**From:** Laura Gibbons <Laura.Gibbons@arun.gov.uk>  
**Sent:** 16 February 2021 15:43  
**To:** Planning.Responses <Planning.Responses@arun.gov.uk>  
**Cc:** Simon Davis <Simon.Davis@arun.gov.uk>  
**Subject:** RE: Planning Consultation on: Y/3/21/DOC

**Subject:** Planning Consultation on: Y/3/21/DOC

**Site Address:** Land at Bilsham Road

**Description of Works:** Approval of details reserved by condition imposed under Y/91/17/OUT relating to conditions 9-surface water drainage scheme & 12-foul drainage scheme.

P:19-326 - Bilsham Road, Yapton RMT Technical Drawings 000 Series 19-326-010 Preliminary Engineering Layout Sheet 2 of 2.dwg

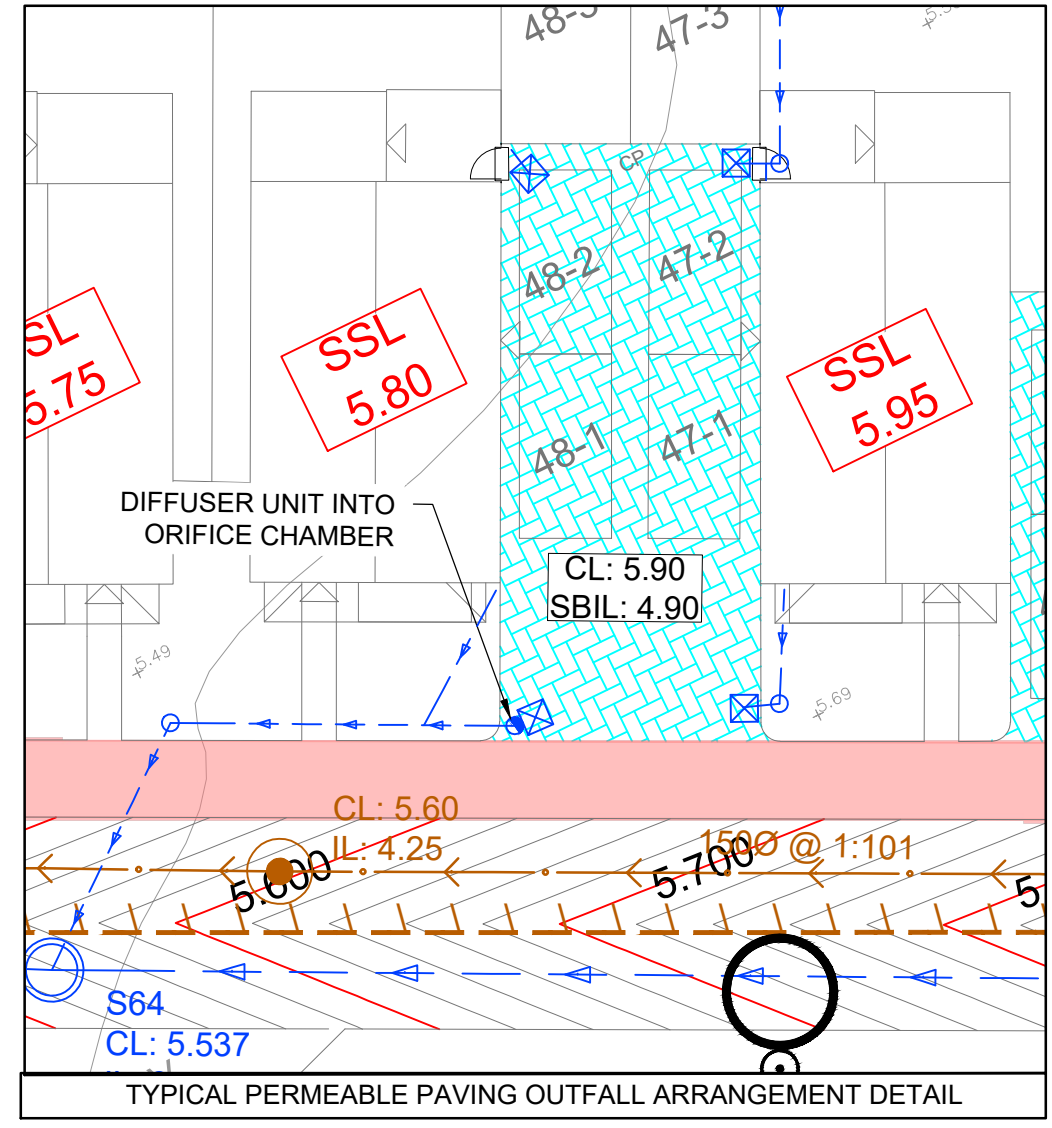
1. Infiltration testing was completed in February 2019. Only one test was completed in each location and tests were abandoned quickly. It can be observed that some test pits did show a decrease in water level over the monitoring period and the tests appear to have been terminated because of time constraints rather than evidence of water not falling. I note that in previous correspondence with the applicant it was agreed to ignore infiltration in site design. In the future it should be noted that a greater allowance of time should be given for infiltration testing.
2. Groundwater monitoring results must be provided and should be overlaid on detailed drainage layout drawings.
3. Detailed layout plans must be provided.
  - a. All pipes must be labelled with diameters and falls.

- b. Manhole invert and cover levels must be provided.
  - c. Catchpits must be clearly identified.
  - d. Finish and formation levels of permeable paving must be detailed on plan.

- e. Layout plans must show connections from roads, driveways and plots to the drainage network.
  - f. Hydrobrake unit references must be detailed on plans and construction detail drawings.

- g. The invert level of the proposed connections to the culvert and watercourse must be provided, along with the invert level of these existing features at the proposed points of connection. Upstream and downstream bed levels of watercourses must also be provided on plans.

9. A detailed review of calculations has not yet been undertaken due to the above. Please ensure that pipe reference numbers are included on layouts to facilitate review.

10. 300mm freeboard must be provided on all basins.
  11. Construction detail drawings must be supplied. Please supply construction detail drawings of basins, permeable paving, manholes, catchpits, flow control devices, headwalls, pipe bed and surround, etc. Basin construction details must include a minimum of two perpendicular cross sections per basin. Details should be site specific.
